DECISION DELEGATED TO HEAD OF PLANNING

Application No: H23-0354-25 **Applicant:** Wright Engineering
Proposal: Proposed bungalow consisting of 6 shipping containers - Part Retrospective
Location: Fenland Lodge Cranesgate South Holbeach St Johns
Terminal Date: 16th December 2025

SOUTH ELEVATION 1:100

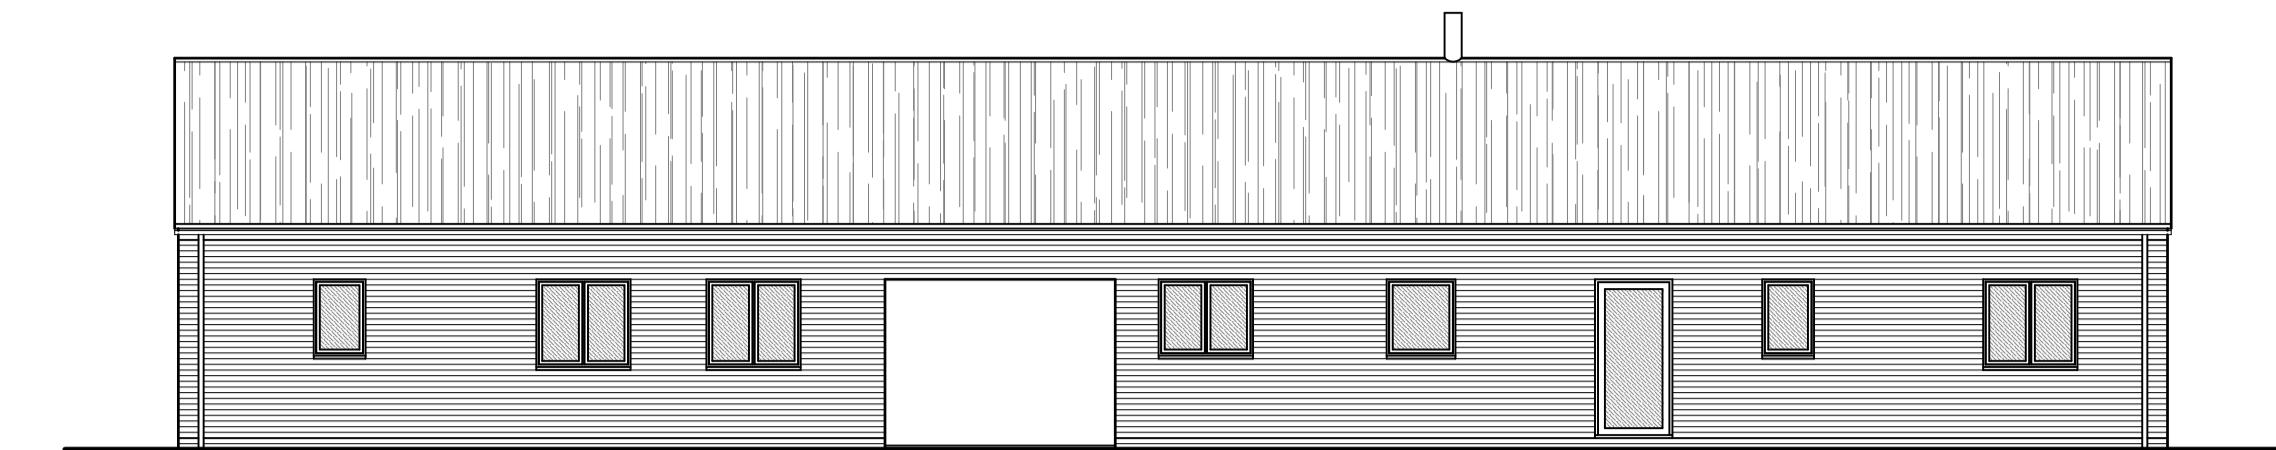
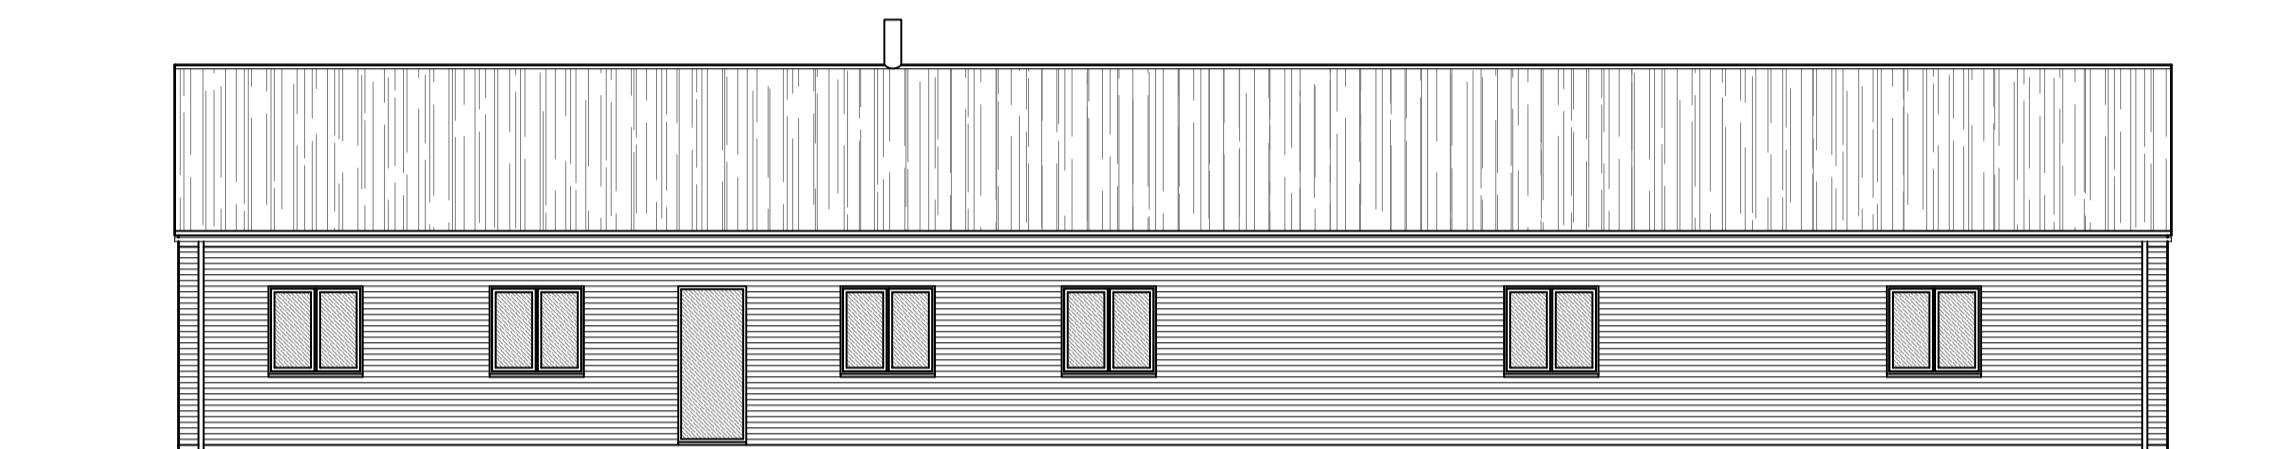
It would have a height of 5100mm to the ridge and 2900mm to the eaves, whilst having a total length of around 26300mm and a width of 10100mm. Whilst this can be seen as being rather excessive and significant in size, it should be noted that there are various different designs of dwellings in the immediate area and a dwelling of this size would not appear at odds with the area as a result of this.

Furthermore, the height and design of a bungalow is inclusive to the area also due to there being bungalows close by as well. Finally, it is also believed to be this size due to featuring rooms as a main house and a smaller section for a housekeeper. Overall, the size and siting of the dwelling from a character perspective is considered to be acceptable and proportionate for the site and wider area.

Beyond this, concern could be raised due to the bungalow actually being constructed from shipping containers, from the materials listed within the application form it shows that it would feature pale coloured bricks on the walls and roof tiles. As such, the materials of the proposed bungalow would be fairly typical and standard to residential developments such as this.

Overall, the size and design of the proposed dwelling is considered to be acceptable and suitable in comparison to the wider area and should not cause harm to the street scene or locality once constructed; subject to a suitable condition that would control the external appearance by way of details relating to materials.

SITE PLAN - PROPOSED |:250

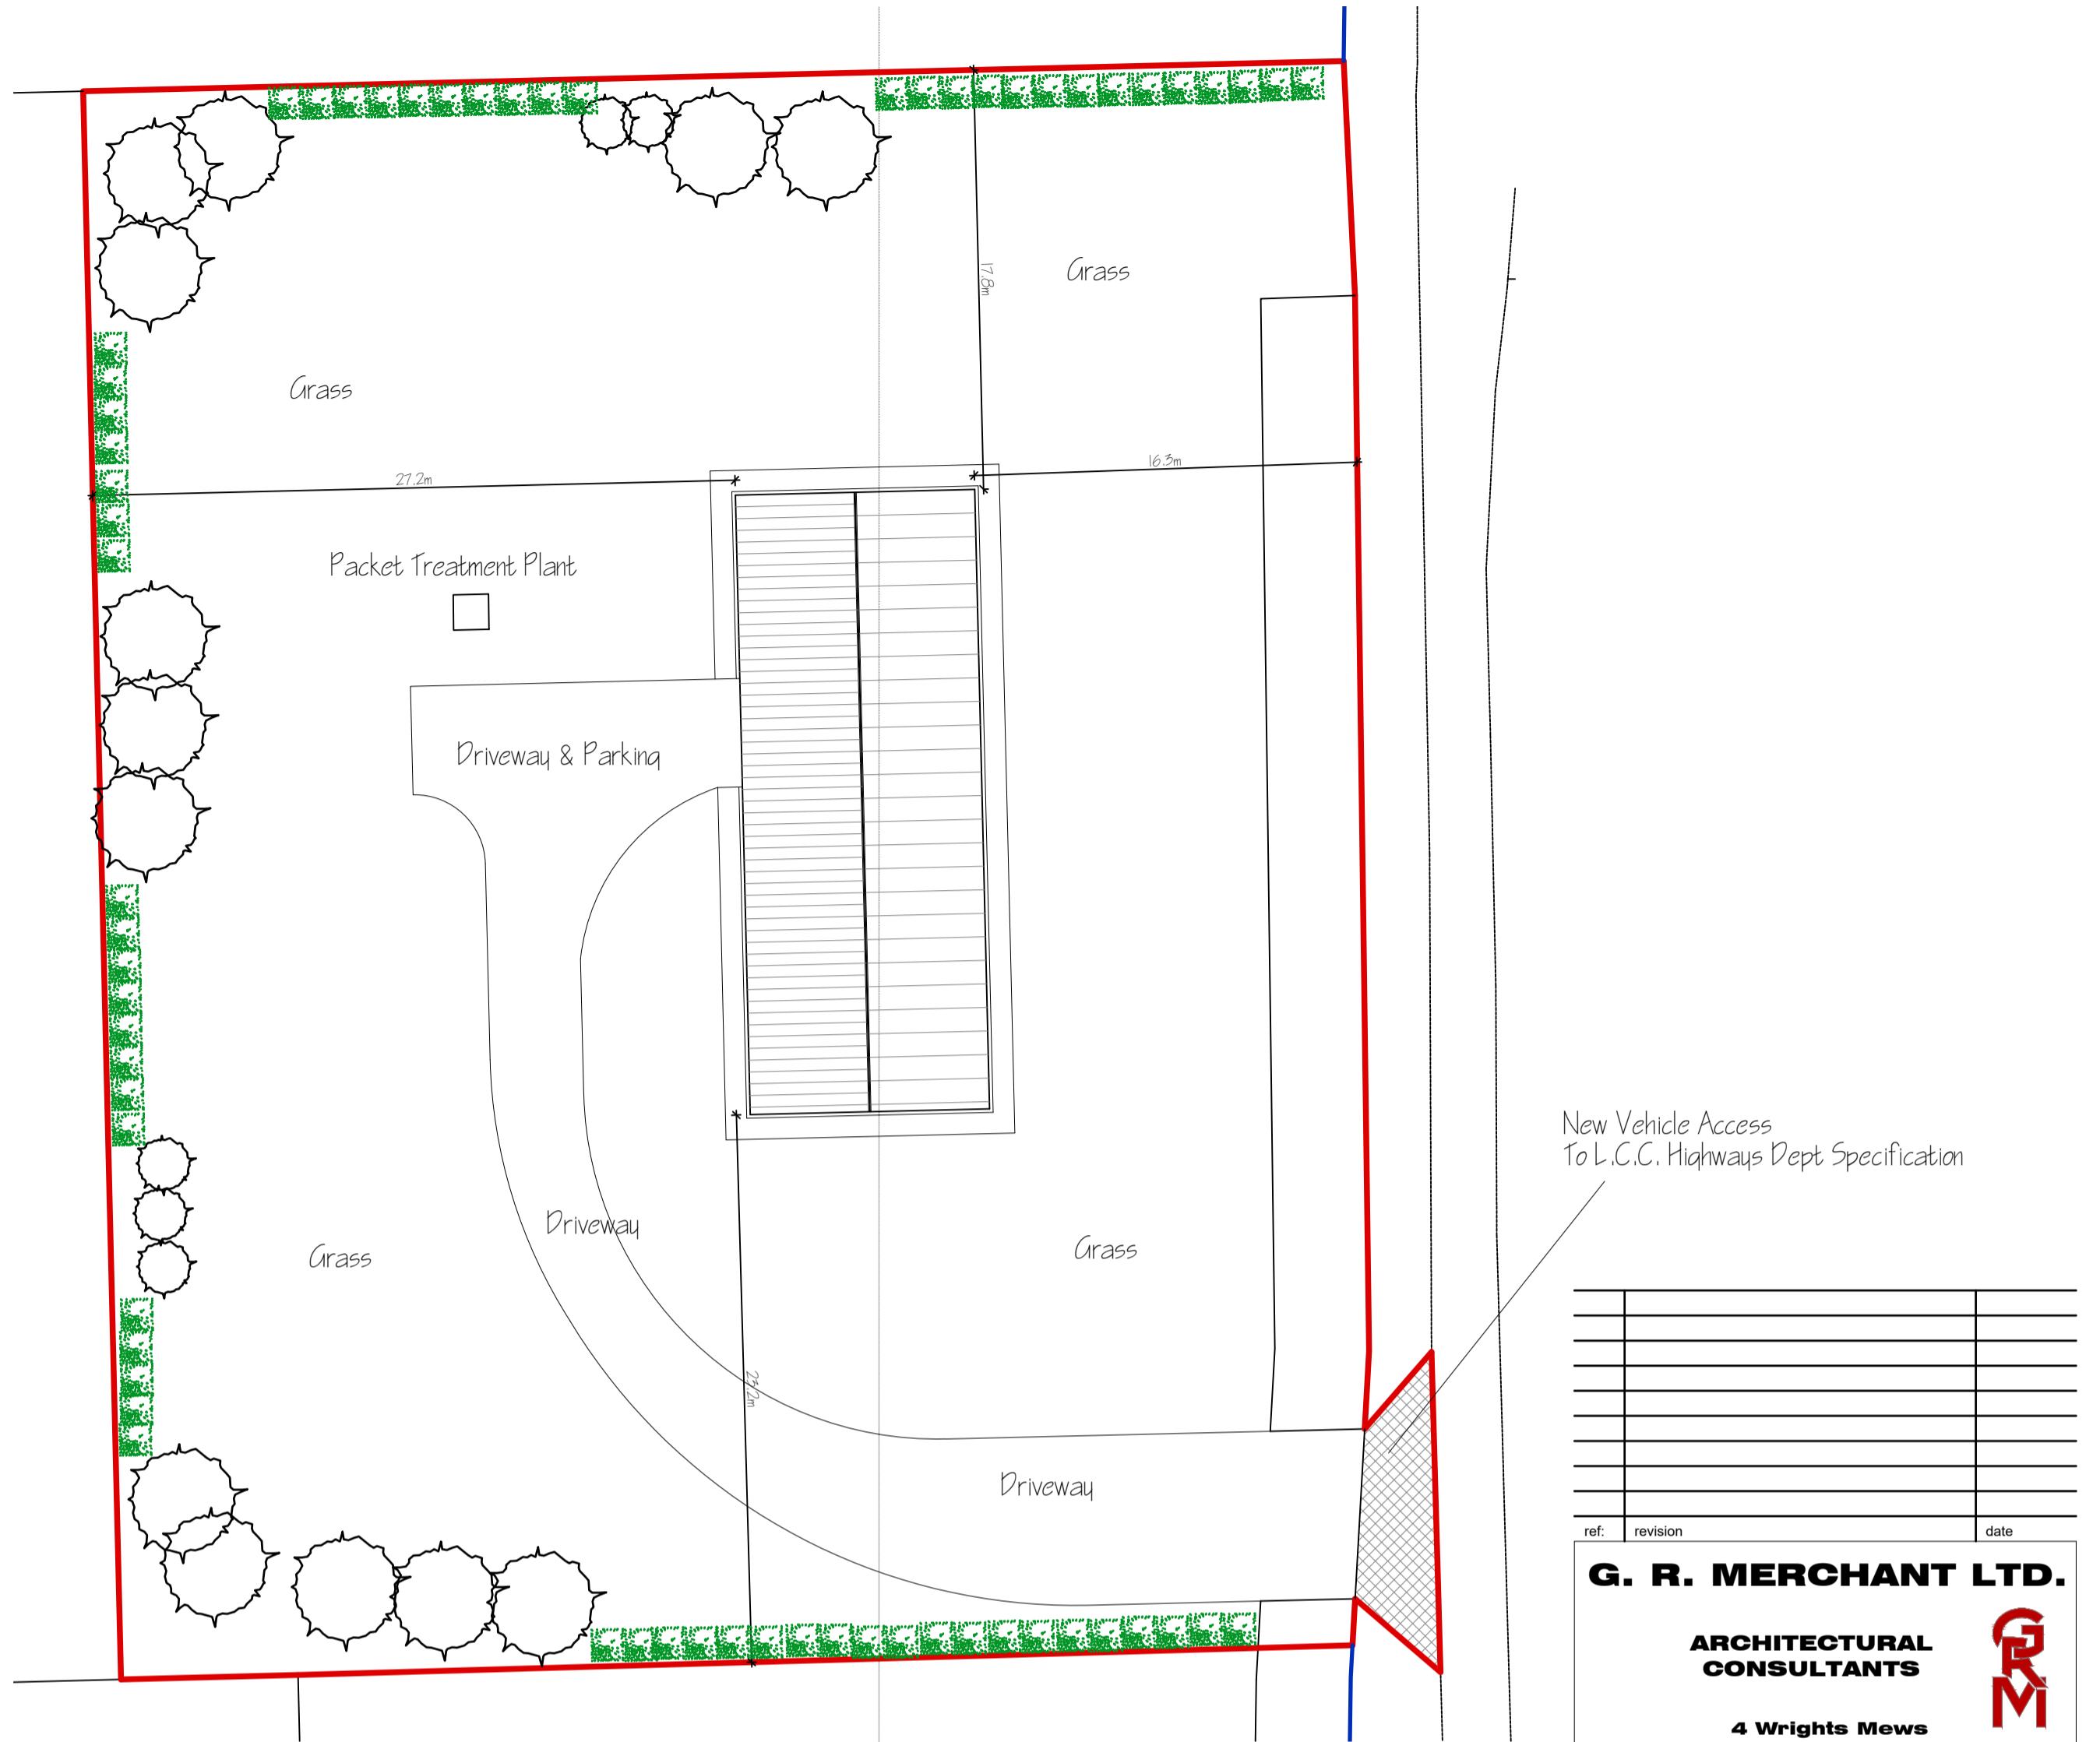
A total of five bedrooms have been included within the plans for this submission, four of which will be in the main part of the house whilst one would be within the housekeepers section. Although Appendix 6 does not stipulate the number of bedrooms required for five bedroom houses, it would be assumed that at least three spaces would still be needed.

In any case, a large driveway and turning area is shown on the site plan as well as a one bay garage. As such, a more than adequate amount of parking can be accommodated for in this regard.
